**EPC Site Plan – SEC 86<sup>th</sup> Street & Bridge Blvd SW****Applicant Comment Response Memo for:****CONDITIONS OF APPROVAL**

Project #: 2020-004098 / SI #: 2024-01284 - Site Plan – EPC

TABLE OF APPLICABLE STANDARDS FOR DEVELOPMENT ON PD ZONED PROPERTY

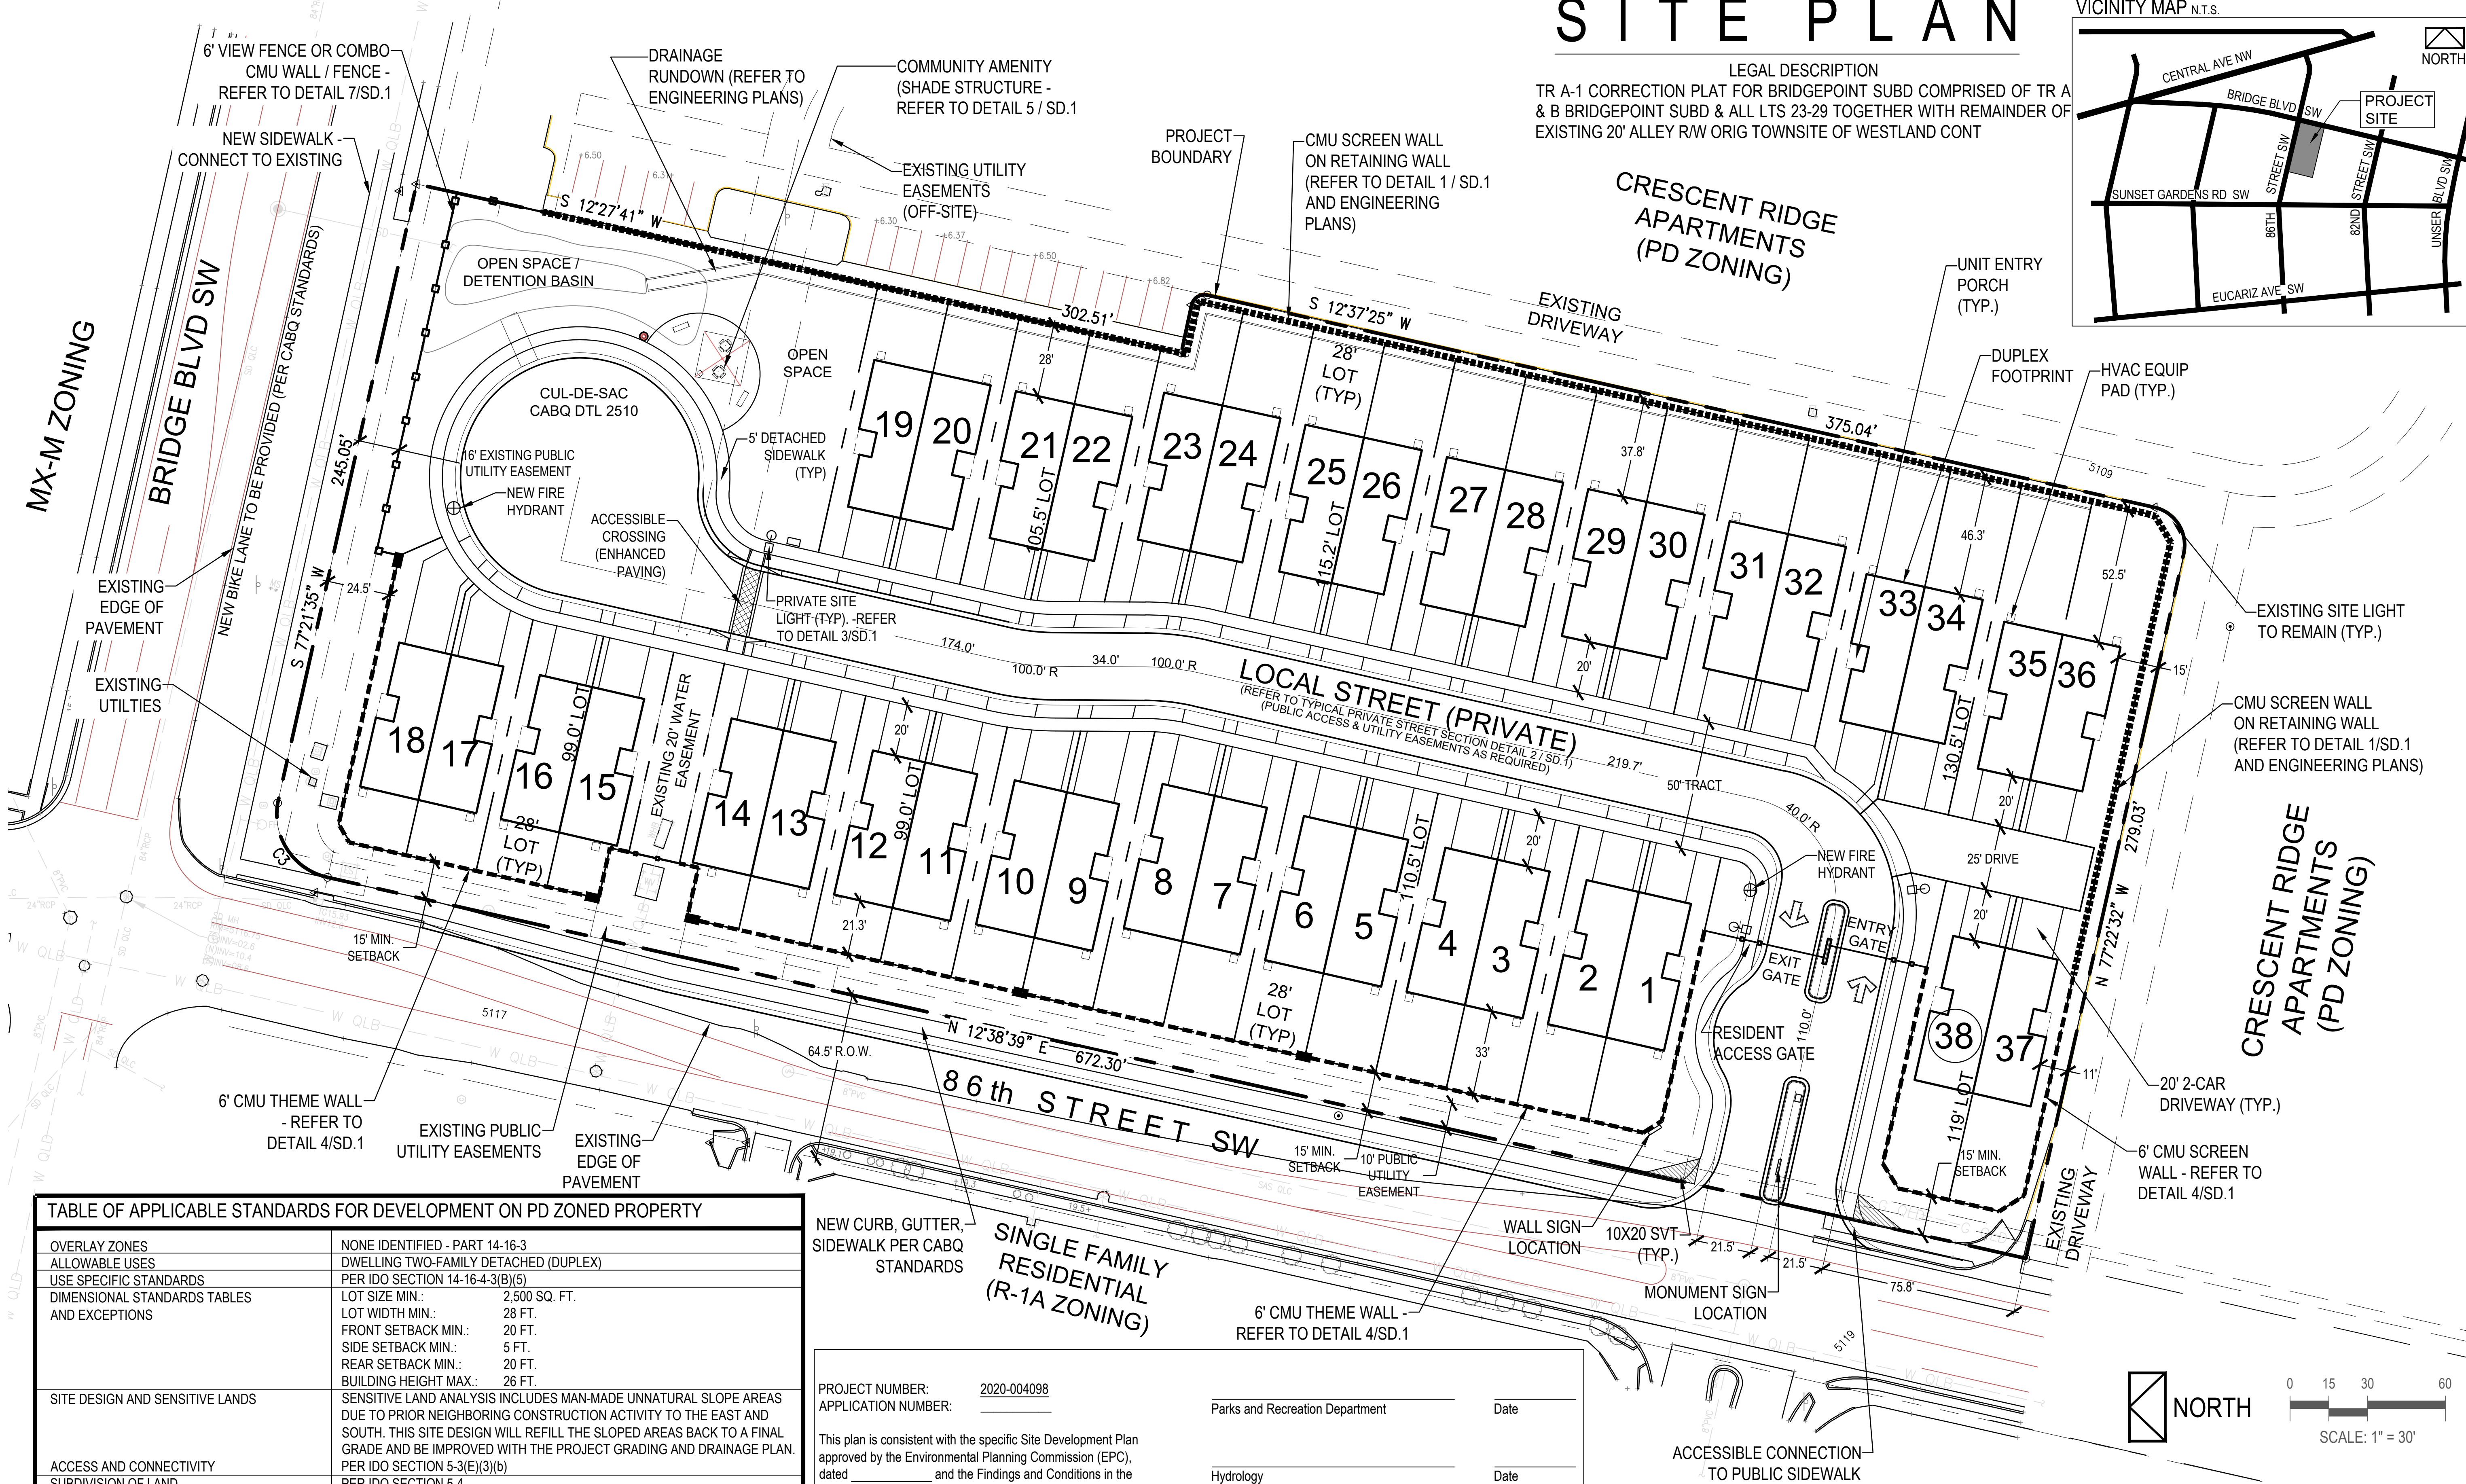
6. Site Plan:
  - A. The entry and exit gates for pedestrians/residents shall be noted.

- B. The notation for the existing zoning for the parcel north and across Bridge Blvd SW shall be corrected from MXN to MX-M.

- C. The description “Major Collector” shall be removed from both roadways. It isn’t necessary for the site plan.

D. The “shade trellis” on the site plan sheet shall be renamed “shade structure” to match its name on the detail sheet.

E. The colored utilities lines shown on the site plan shall be changed to black or grey, so they are still visible, but don’t dominate the site plan drawing.

F. TABLE OF APPLICABLE STANDARDS FOR DEVELOPMENT ON PD ZONED PROPERTY:

1. OUTDOOR AND SITE LIGHTING: The description shall read, “15-FT. PREFINISHED OR PAINTED STEEL TUBE LIGHT POLES AS INDICATED AND REMAINDER PER IDO SECTION 5-8.”
2. LANDSCAPING, BUFFERING, AND SCREENING: The description shall state, “STREET TREES PER STREET TREE ORD. 6-6-2-4, MULCHING PER IDO 5-6(C)(5)(E) AND PONDING PER CITY STANDARD SPEC., SECT. 1013 AND REMAINING AS INDICATED ON LANDSCAPE PLAN.”

A. The location of the monument sign and wall sign shall be identified on the site plan sheet.

*Applicant Response – Notation has been added to the site plan.*

*Applicant Response – Correction has been made.*

*Applicant Response – Notations have been removed.*

*Applicant Response – Correction has been made.*

*Applicant Response – Correction has been made.*

*Applicant Response – Additions to the Development Standards table have been included.*

*Applicant Response – Sign locations have been indicated on the site plan sheet.*
